**Development Application and Planning Proposal Review
NSW Planning Portal Concurrence and Referral**

Authority	Authority's Reference	Agency Concurrence and Referral	Authority Contact	Authority Notification	Submission Due	Submission Made
Parramatta City Council	PP-2022-376	Ref-1344	William Jones	10/05/2022	7/06/2022	7/06/2022

Address	Land Title
241-245 PENNANT HILLS ROAD CARLINGFORD 2118	Lots 1, 2, 5 & 6 DP 805059

Scope of Development Application or Planning Proposal

floor plans - ground floor to level 01

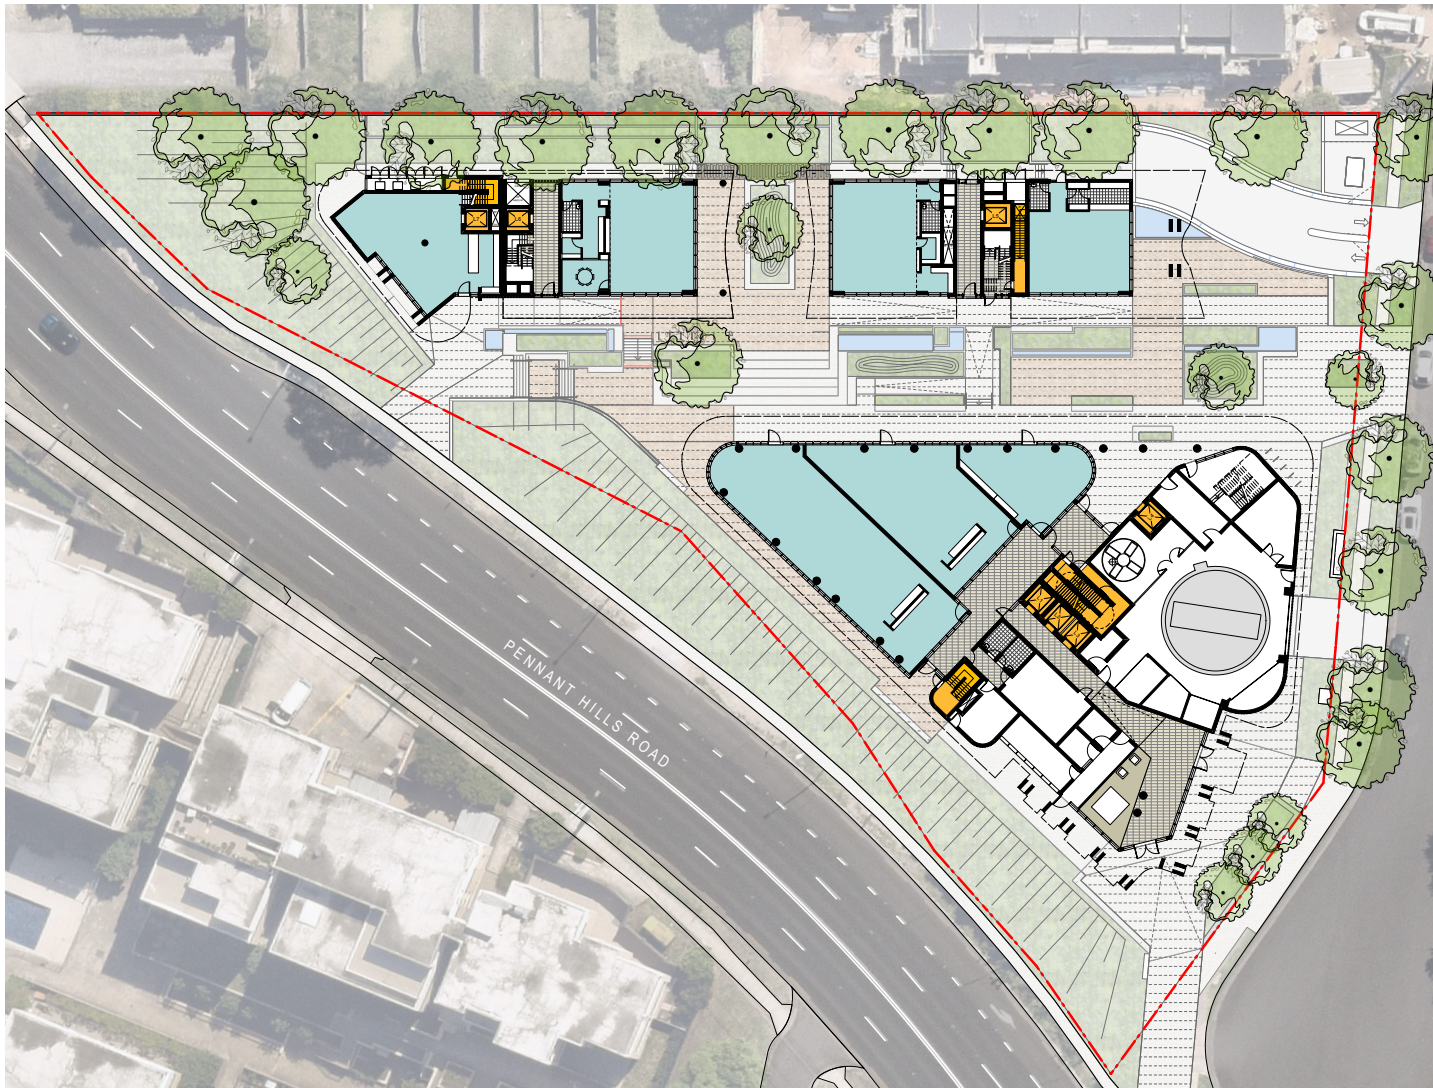
- An extension and / or augmentation of the existing local network may be required. Whilst padmount substation no. 3764 located on the site is likely to have some spare capacity, it is not unlimited and may not be sufficient to facilitate the proposed development. The Indicative Architectural Scheme does not appear to show the existing padmount substation or provision for an alternative / new padmount or indoor substation.

- Any required padmount or indoor substation will need to be located within the property (in a suitable and accessible location) and be protected (including any associated cabling) by an easement and associated restrictions benefiting and gifted to Endeavour Energy. Please refer to Endeavour Energy's Mains Design Instruction MDI 0044 'Easements and Property Tenure Rights'.
- The Planning Report indicates 'The PP includes a private 90 place childcare centre as part of the development of the site'. Whilst there may be no restrictions in legislation that stop sensitive uses such as schools, pre-schools, day / child care centres being placed next to electricity infrastructure, prudent avoidance measures should however be implemented.
